**Walsh Bay Arts and Cultural Precinct (SSD 8671) - Notice of Exhibition  
Lot 11 DP 1138931 (Pier 2/3) and Lot 65 DP 1048377  
(Wharf 4/5 and Wharf 4/5 Shore Sheds), Walsh Bay**

Thank you for your letter dated 20 October 2017, requesting Transport for NSW (TfNSW) review and comment on the above. It should be noted that Roads and Maritime Services will be providing a separate submission on the proposal.

Figure 3.6: Truck approach routes

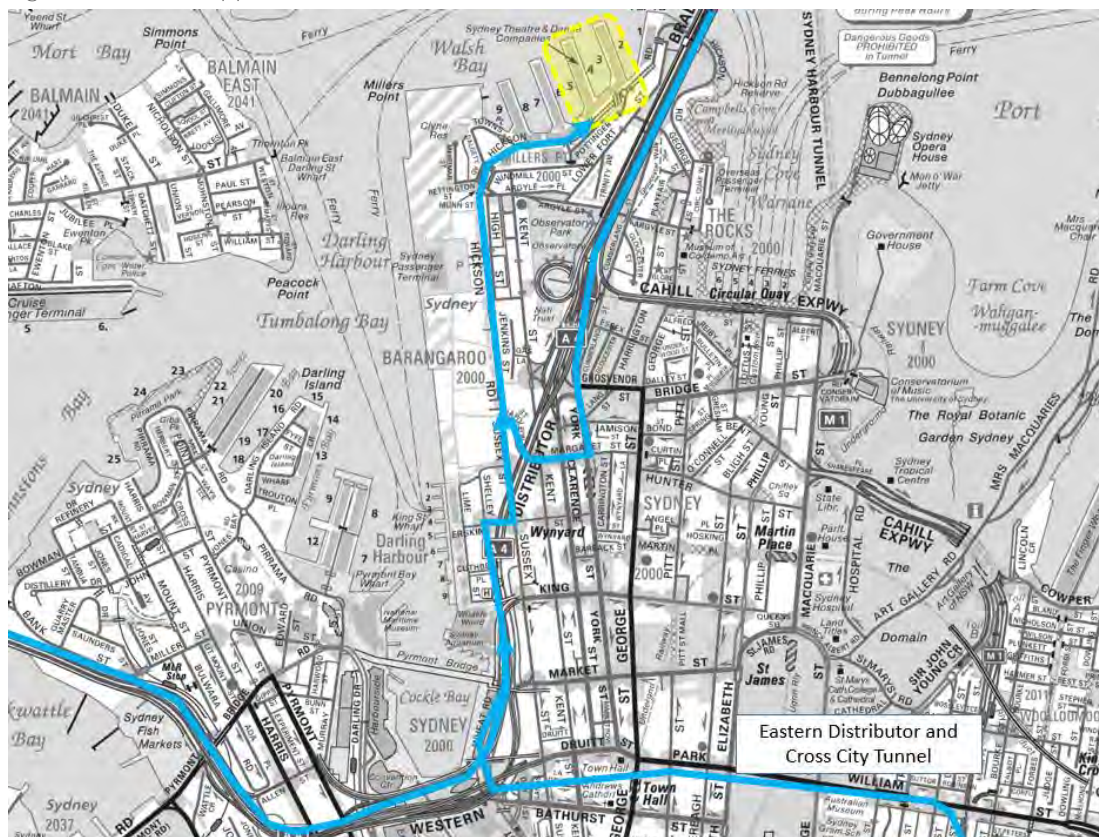
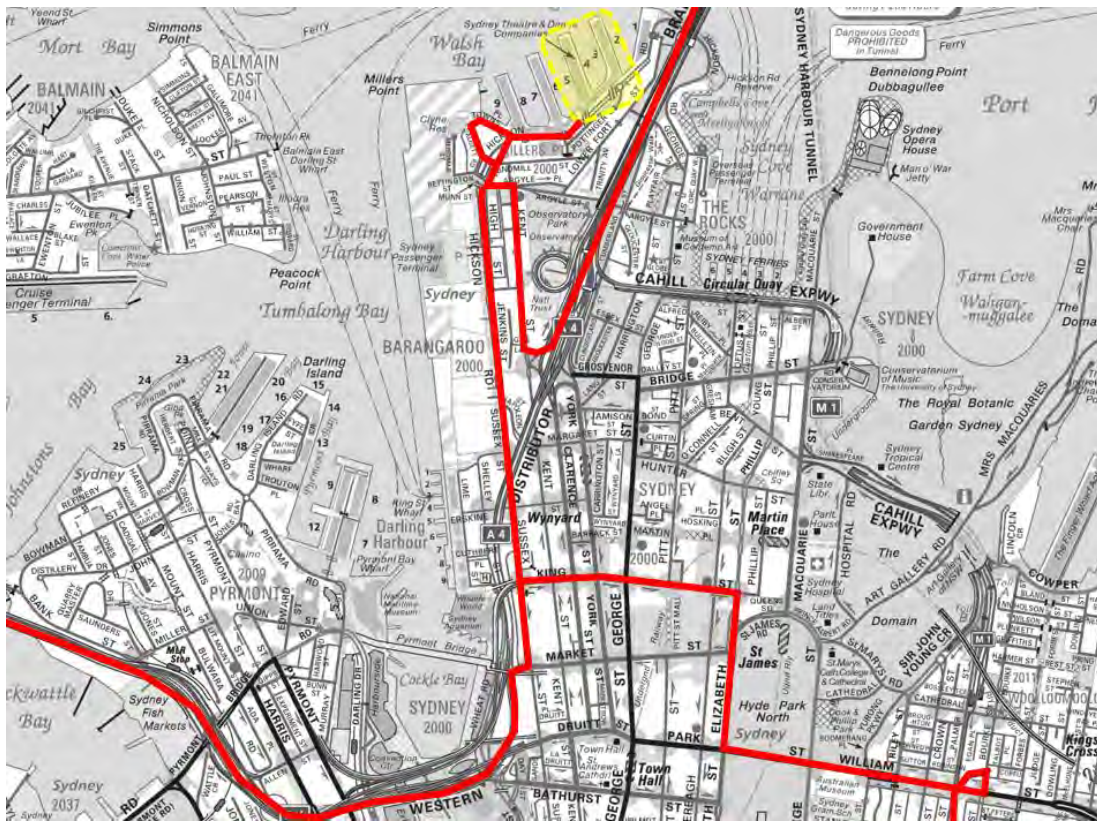
- It is noted that the proposed work zone is positioned after the Hickson Road/Pottinger Street roundabout. TfNSW advises that the route path to follow Hickson Road onto George Street is too narrow for heavy rigid vehicle movements and creates potential conflicts with cyclists and general traffic. TfNSW requests that the applicant consults with the Sydney Coordination Office within TfNSW with regards to the location of the proposed work zone and documents the outcome in the Response to Submissions;

- Location of the proposed work zone;
  - Haulage routes;
  - Construction vehicle access arrangements;
  - Proposed construction hours;
  - Estimated number of construction vehicle movements;

WALSH BAY ARTS PRECINCT
LOADING DOCK - SWEPT PATH ASSESSMENT
6.4m SRV

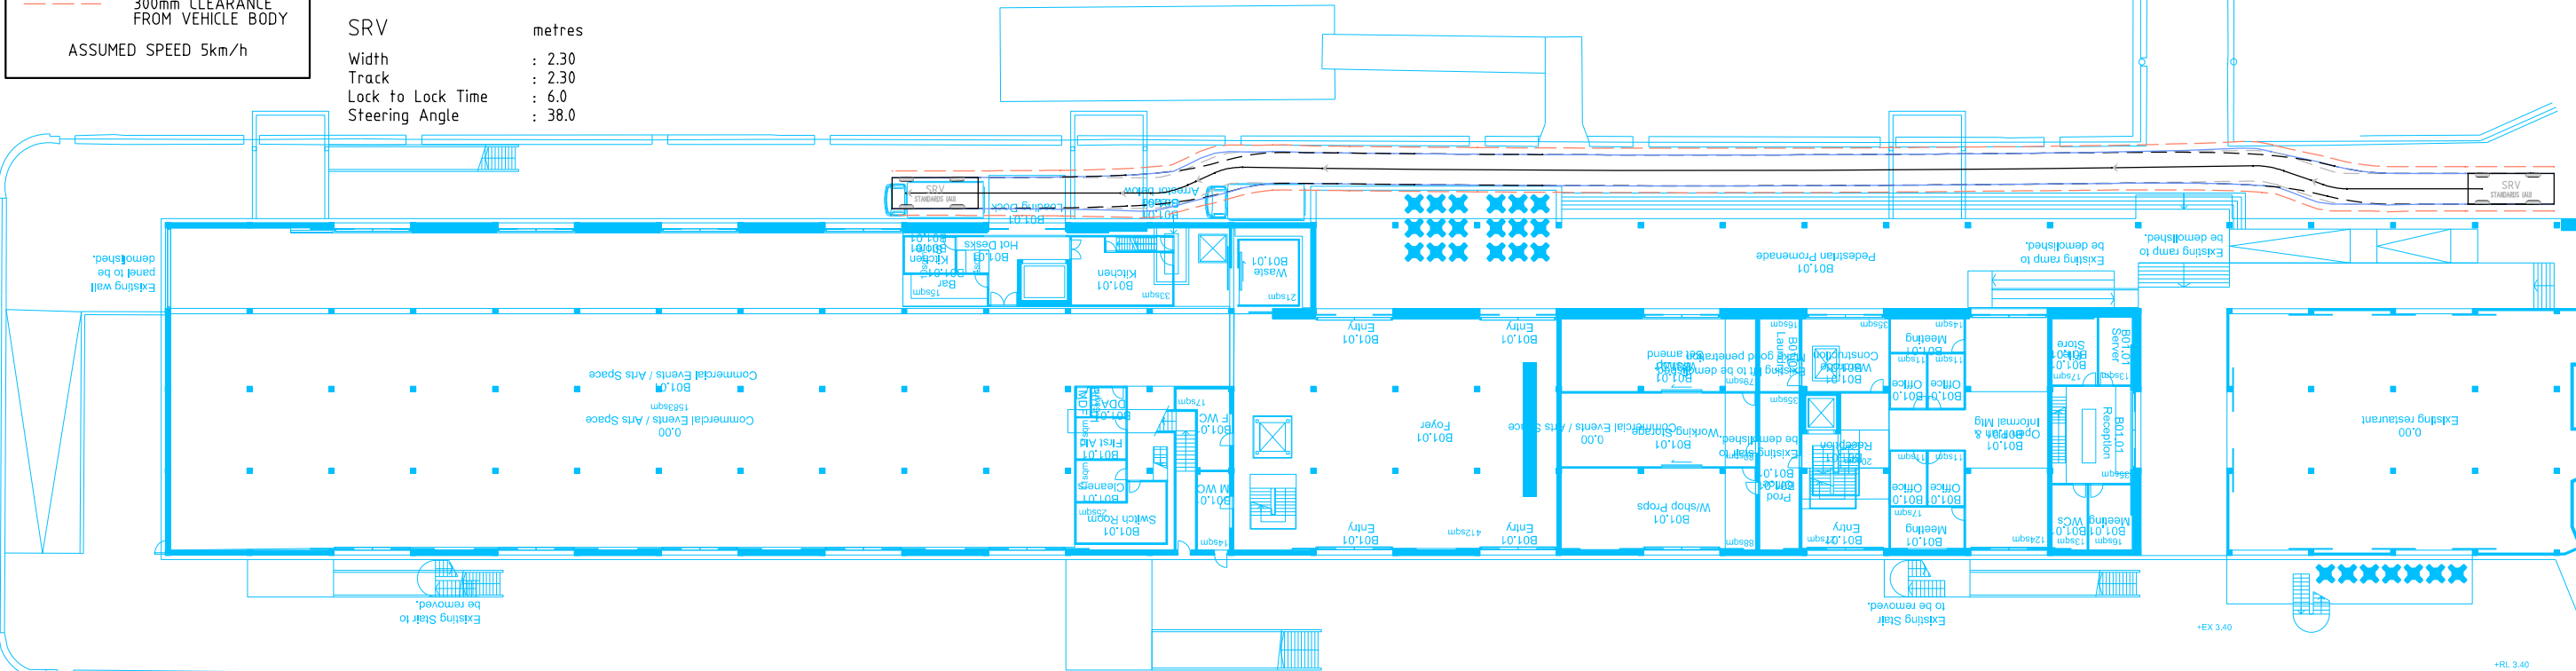
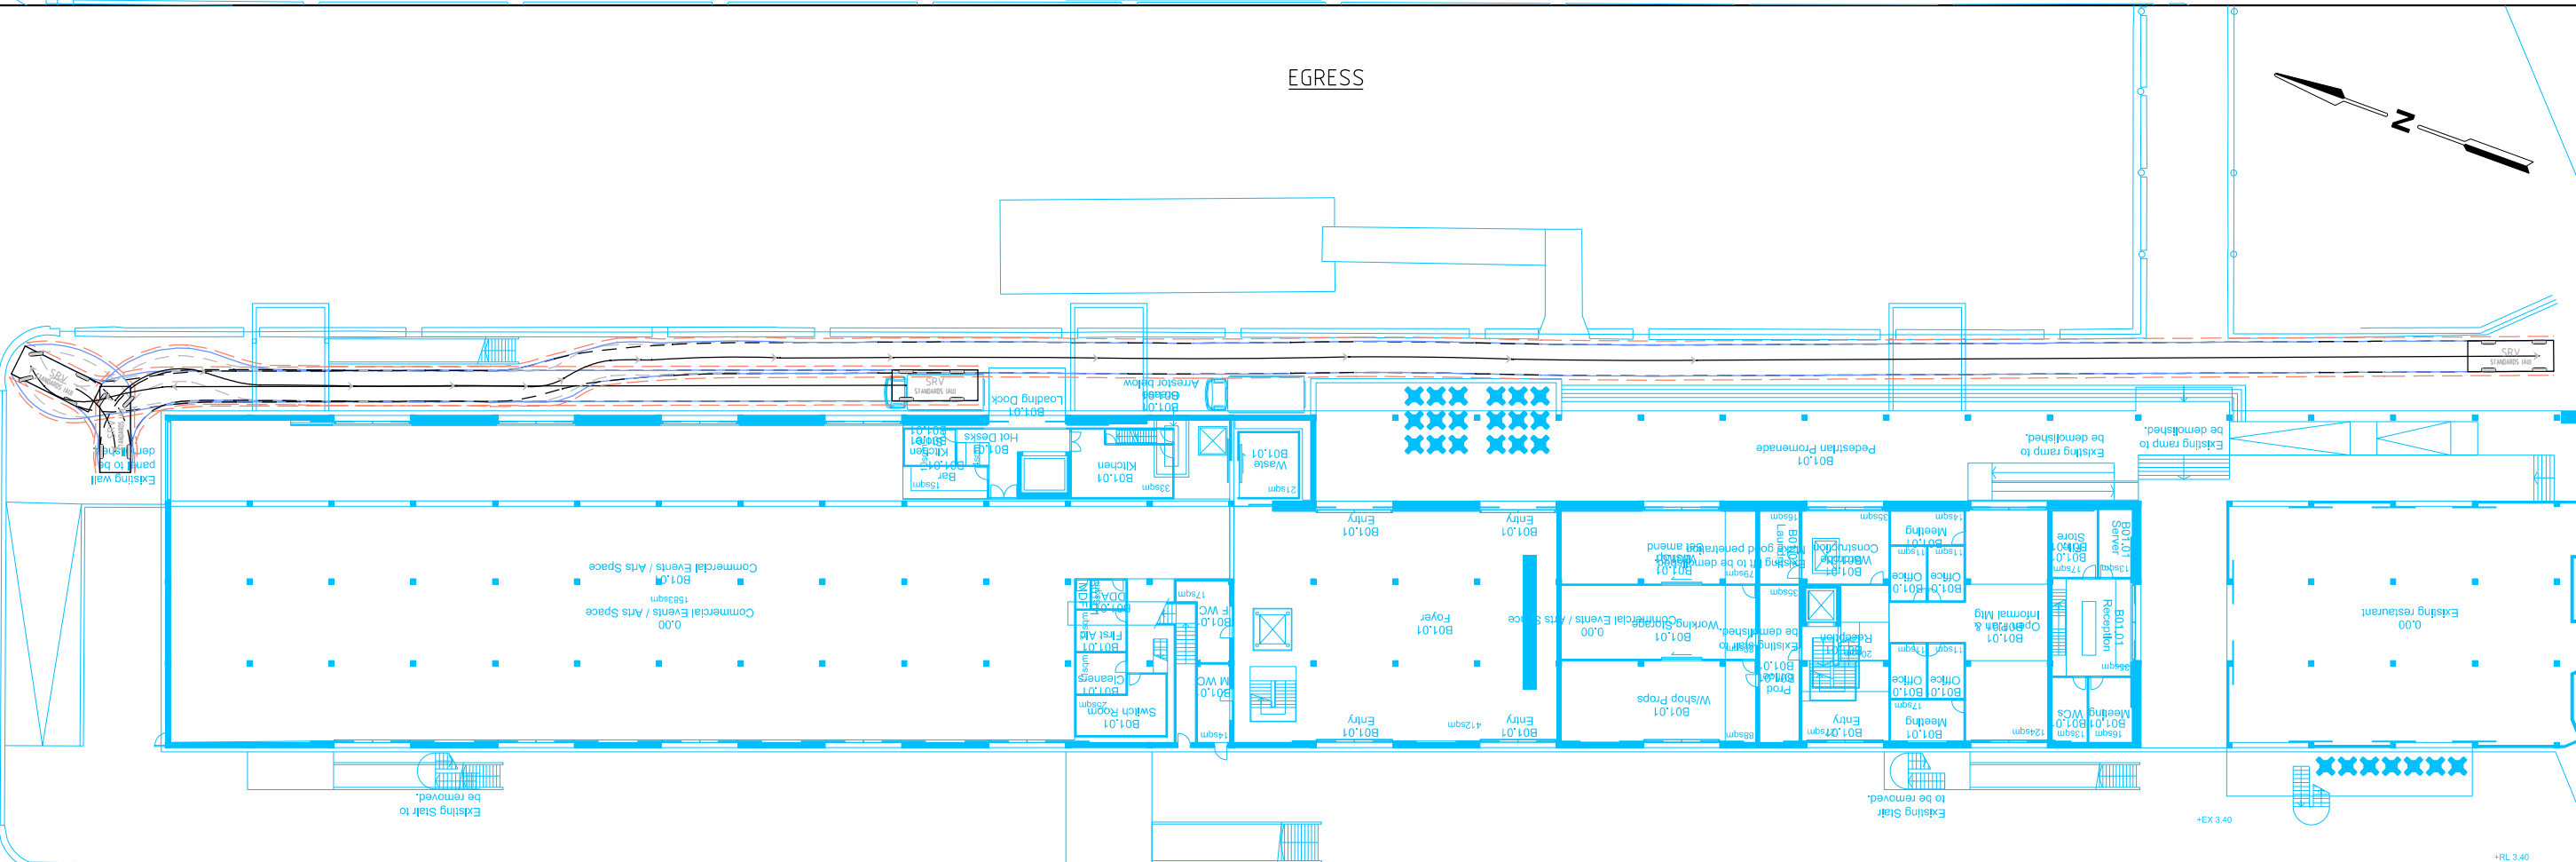
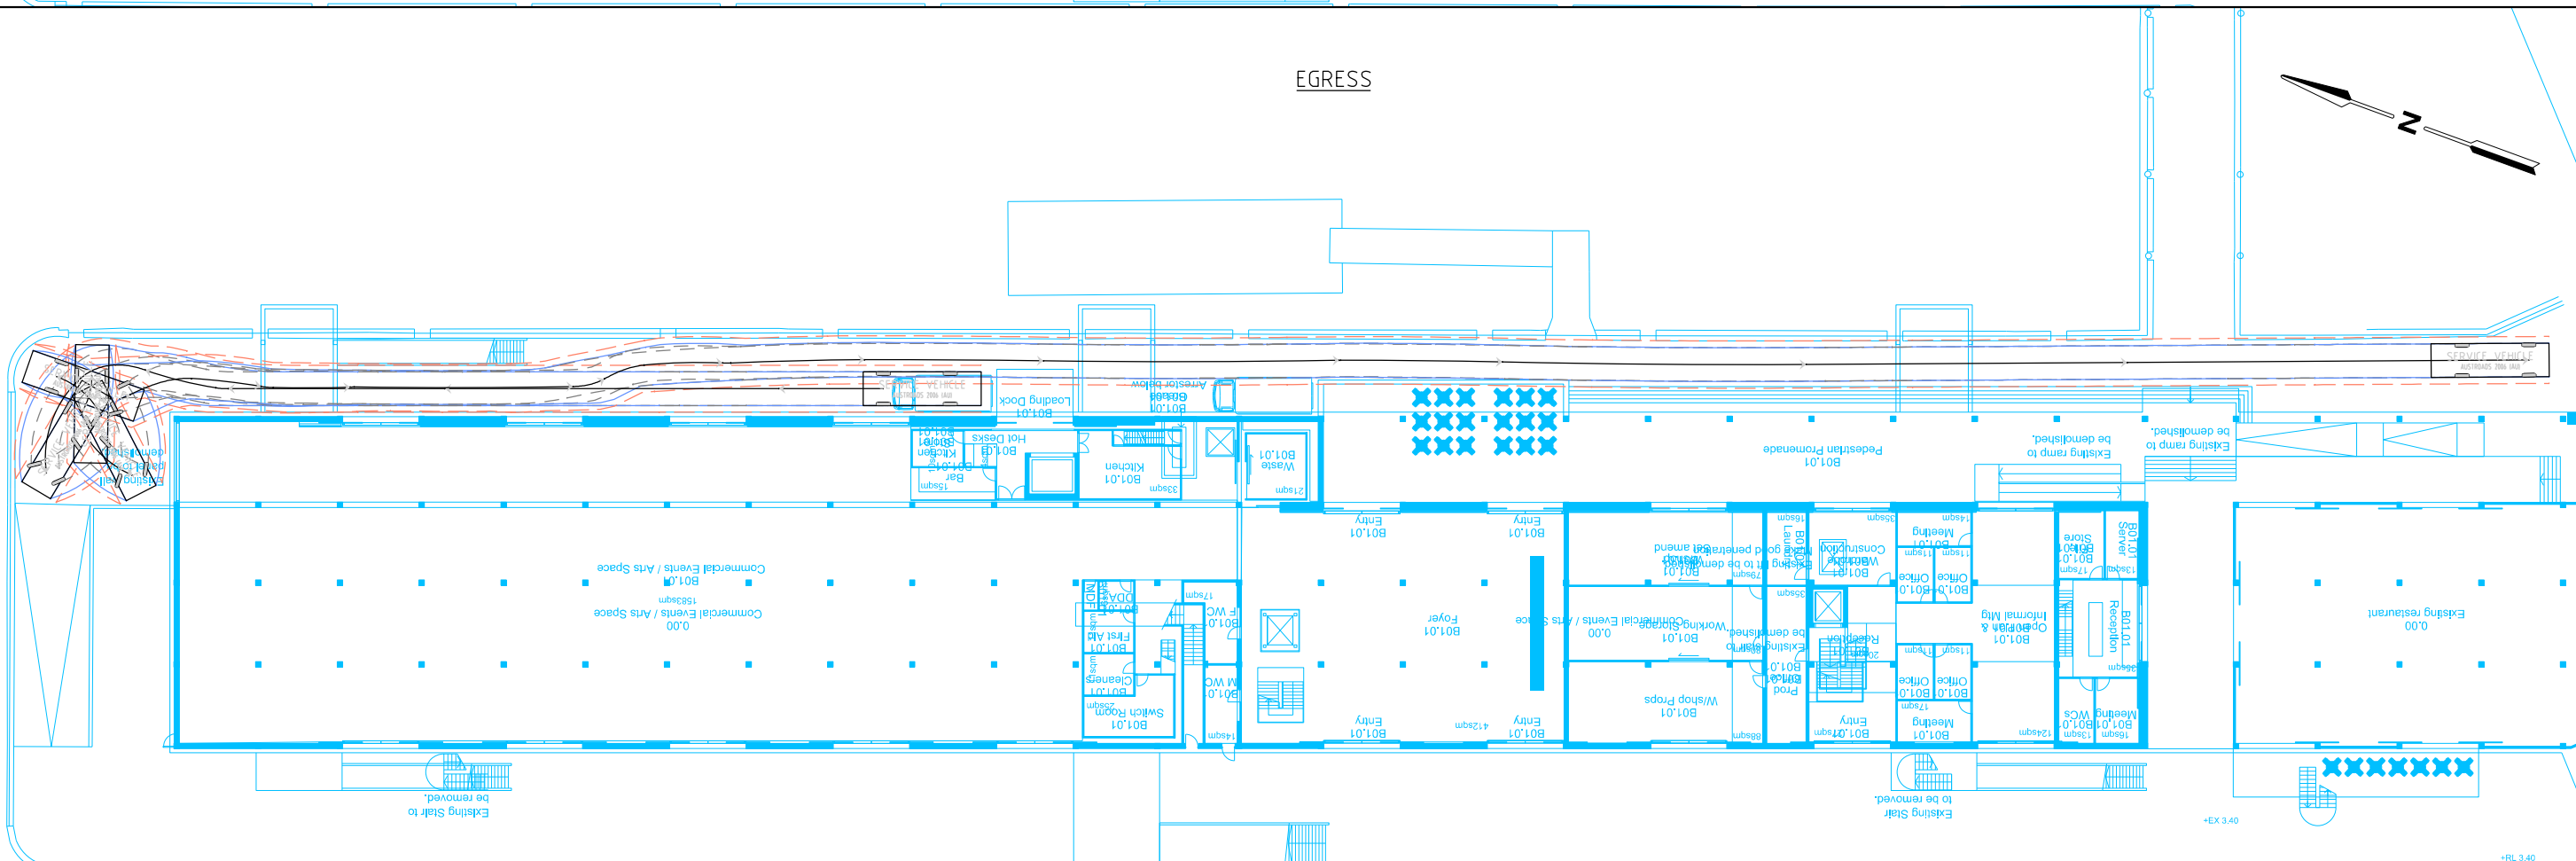
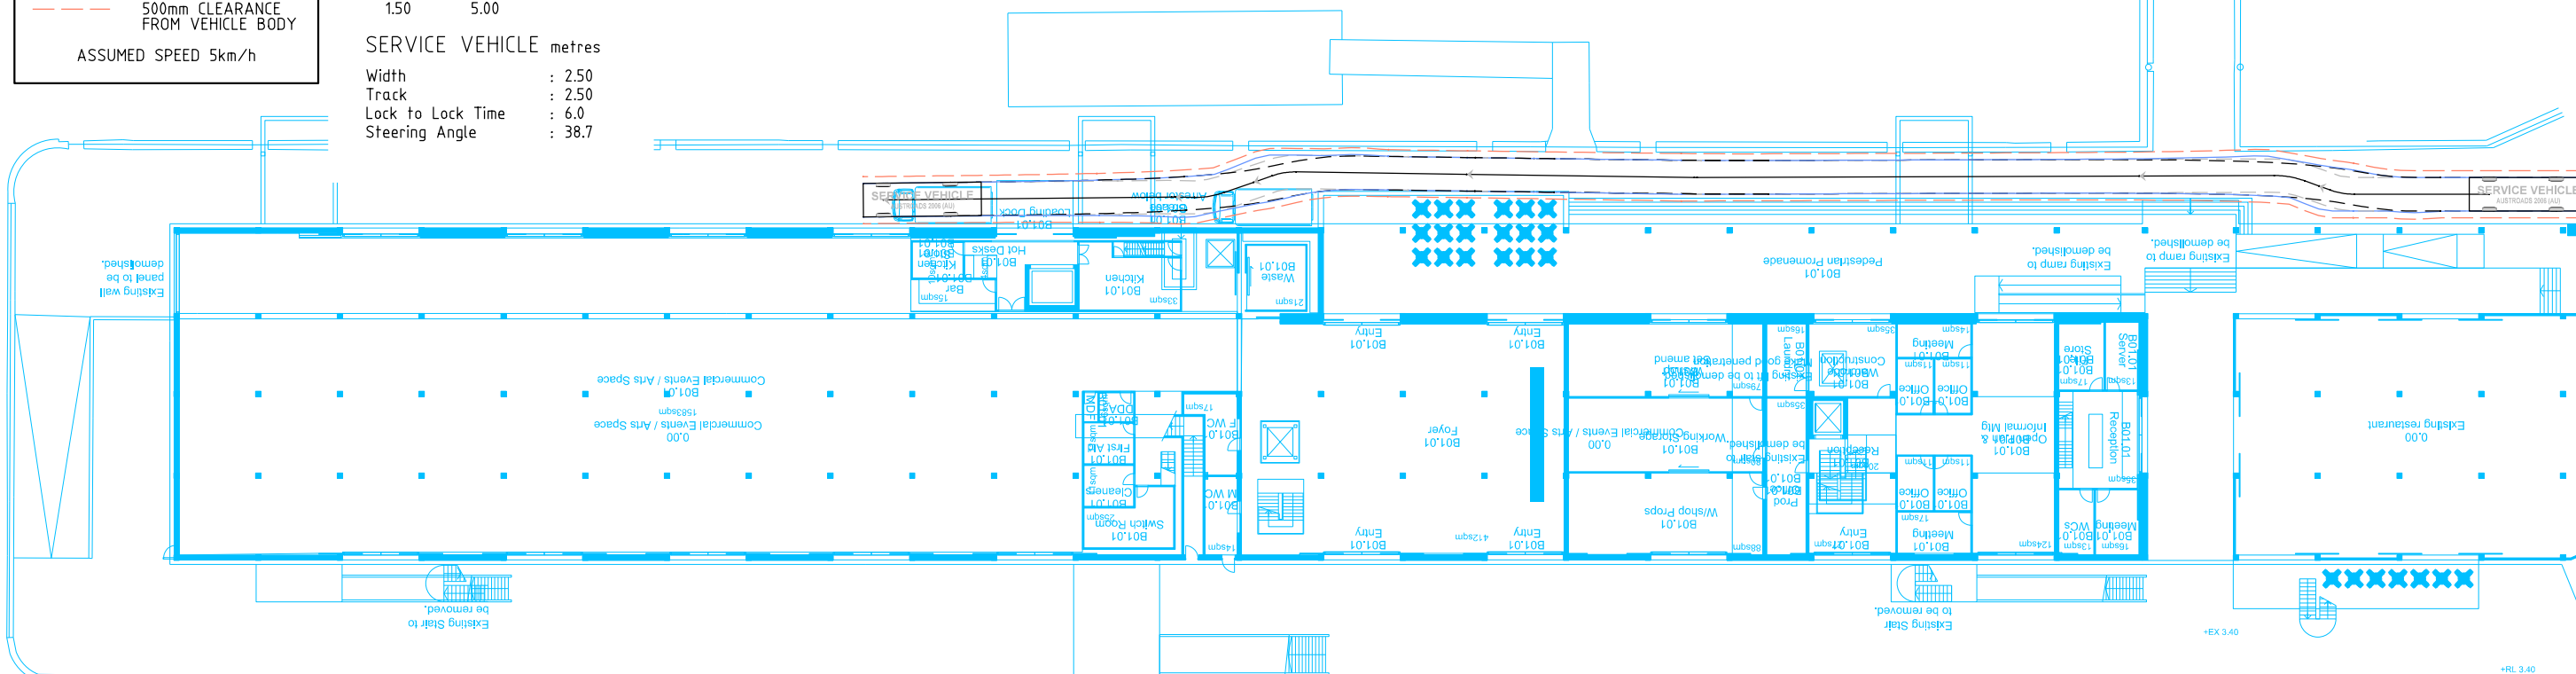
- Any incidents in the service and loading dock area would have the potential to cause queuing on Hickson Road. Therefore, these incidents need to be managed to minimise the impact on the general traffic and bus operation with the CBD;
- The applicant should not rely on the kerbside restrictions to conduct their business activities;
- The development should cater for all loading and servicing to be conducted on-site; and
- Kerbside restrictions are set to suit the wider community needs and are constantly subject to change based on road network requirements.

- Confirm that the vehicle access and circulation areas are designed in accordance with the relevant Australian Standards, including for loading dock areas;
- Plans that show swept paths of the vehicles including simultaneous ingress and egress to the service and loading dock and location of passing bays; and
- Details of any infrastructure works required to support the service and loading operations of the development.

It is requested that the applicant be conditioned to prepare a service and loading dock management plan, in consultation with the Sydney Coordination Office within TfNSW, to minimise impact on the general traffic and bus operation within the CBD. The management plan needs to include, but not to be limited to, the following:
